KIRKLEES METROPOLITAN COUNCIL INVESTMENT & REGENERATION SERVICE

DELEGATED DECISION TO DETERMINE PLANNING APPLICATIONS

Reference No:	2025/62/93523/W
Site Address:	23, Moor Park Avenue, Beaumont Park, Huddersfield, HD4 7AL
Description:	Erection of two storey side and rear extensions and front porch, alterations to roof including increasing height of eaves and associated works
Recommending Officer:	Joanna Rednall

DECISION – Conditional Full Permission

Proposed Front Elevation
1 : 50

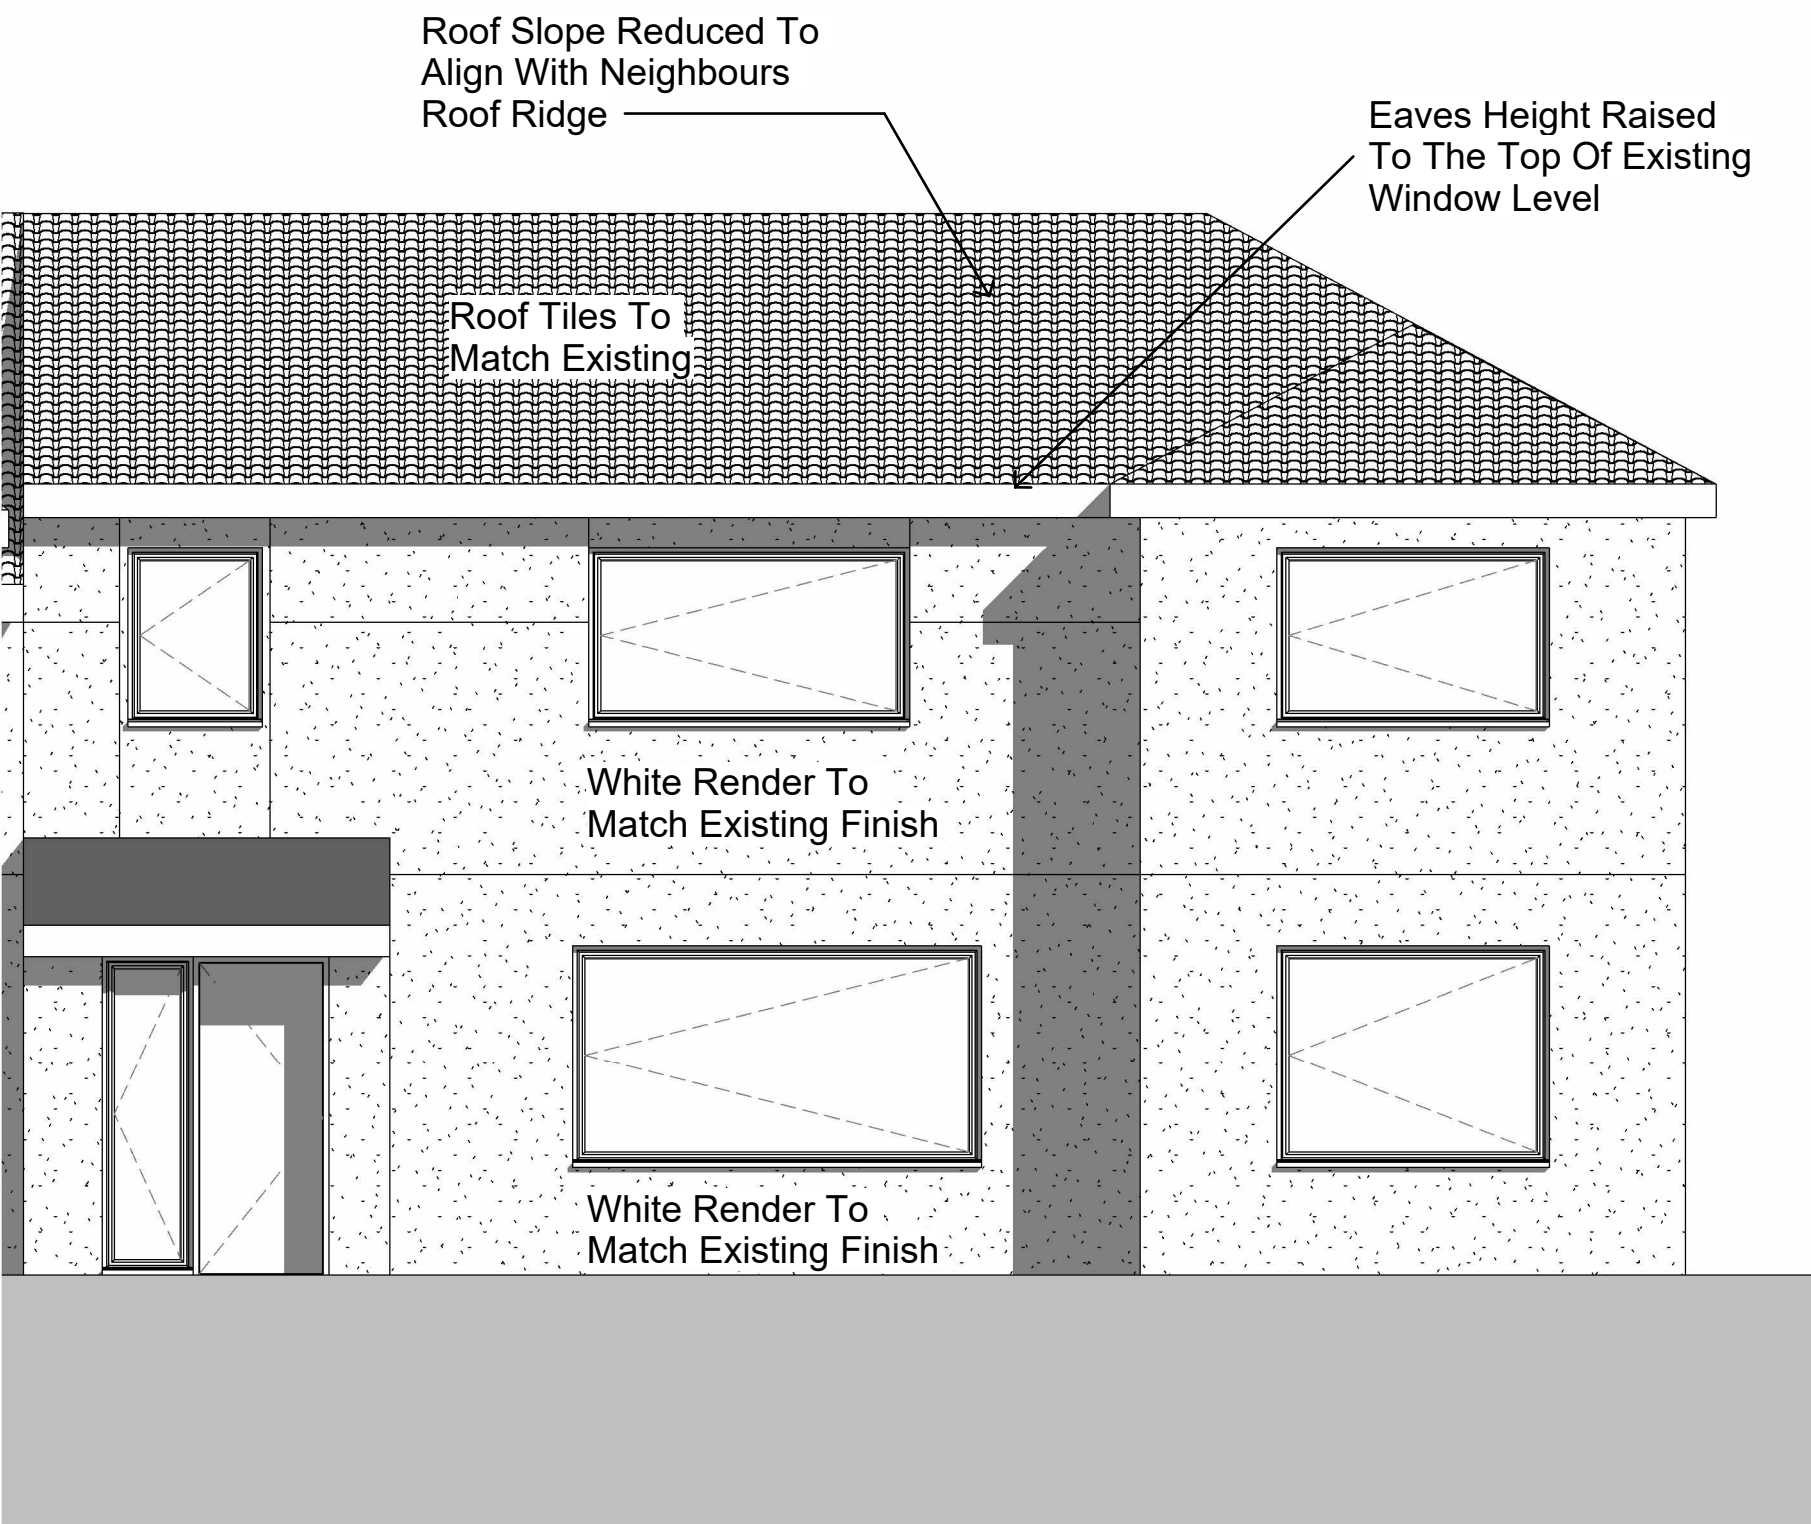
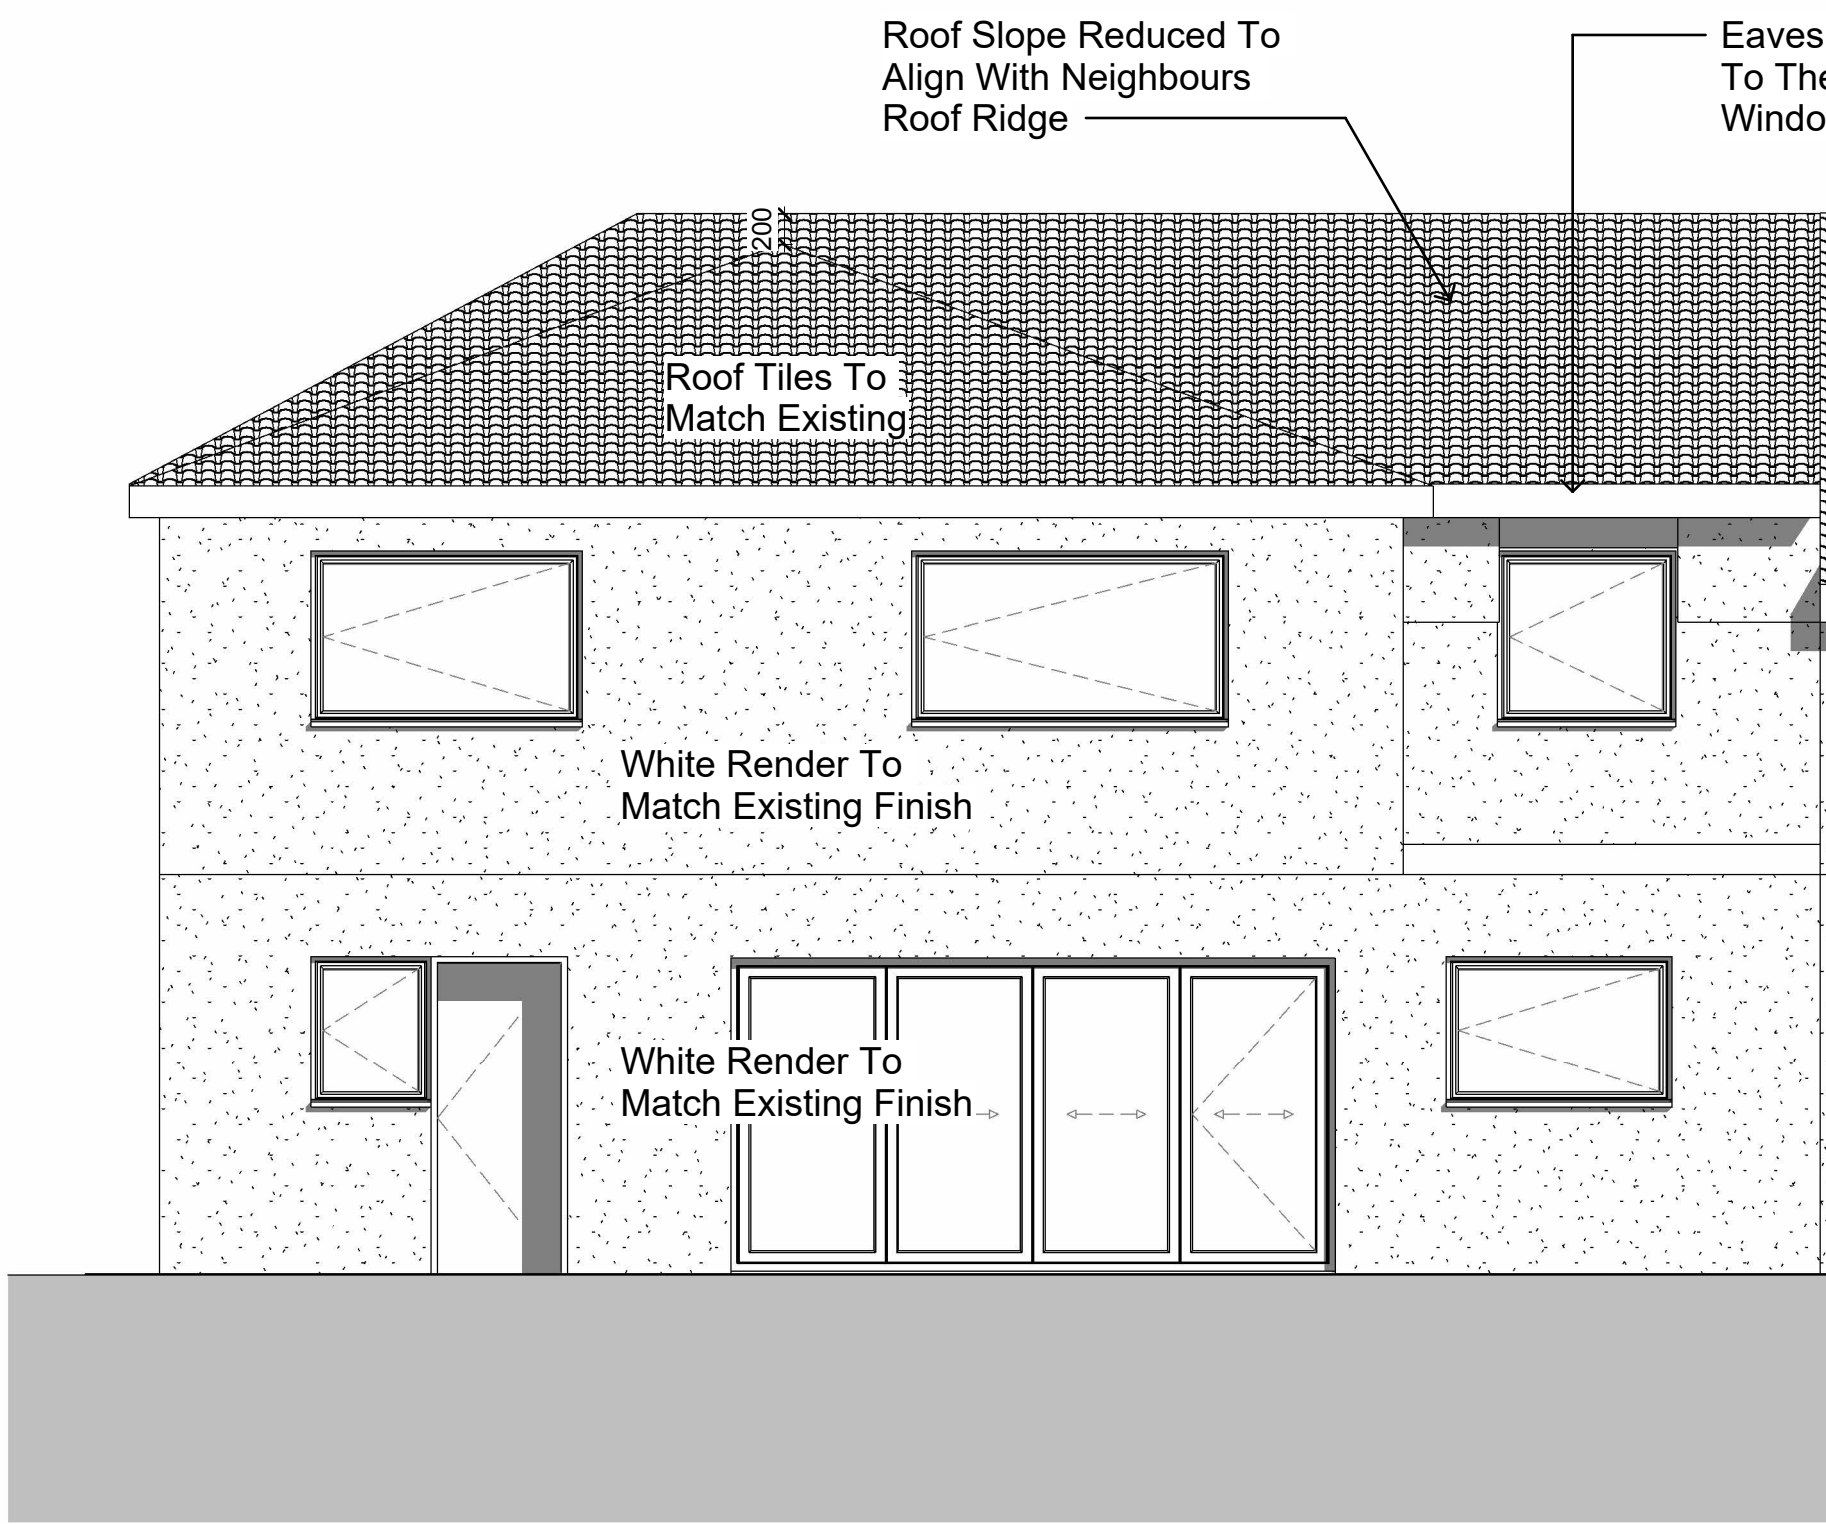
The submitted plans indicate that the extension would project forward by 0.8 metres from the front elevation, which represents a departure from the SPD guidelines. In this instance, the design would reflect that of the adjoining neighbour, which similarly benefits from a modest forward projection. As such, the proposal would not appear unduly prominent or incongruous when viewed within the context of the wider street scene. When assessed in relation to the host dwelling, the extension would remain clearly subservient, incorporating a limited width and a set-down ridge height, resulting in a balanced and proportionate addition. Officers therefore consider the forward projection of the two-storey side extension to be acceptable and not harmful to the visual amenity of the area.

With regard to the front extension, this would measure 2.5 metres in width and project 2 metres from the front elevation of the dwelling. The extension would be set well back from the pavement, retaining a separation distance of approximately 8 metres. It would be small and subservient in scale, with materials matching those of the existing dwelling. As such, the porch would not result in harm to the character or appearance of the host property or the wider street scene.

In addition to the extensions, a number of alterations are proposed, including an increase in eaves height from 4.2 metres to 5 metres, a reduction in the roof pitch to align with the adjoining neighbour, and the removal of the existing

front bay window. These alterations would help to maintain visual symmetry between the application property and the neighbouring dwelling and would not result in any adverse visual impacts. Given their limited scale, the alterations are considered to be in keeping with surrounding properties and sympathetic to the host dwelling.

The proposed front-facing windows would overlook the highway, while the rear-facing windows would be positioned approximately 16 metres from No. 16 Moor Close. Due to the orientation of this neighbour, the proposal would face the side elevation of No. 16, which includes a small first-floor side window, likely serving a hallway or bathroom. Given the separation distances,
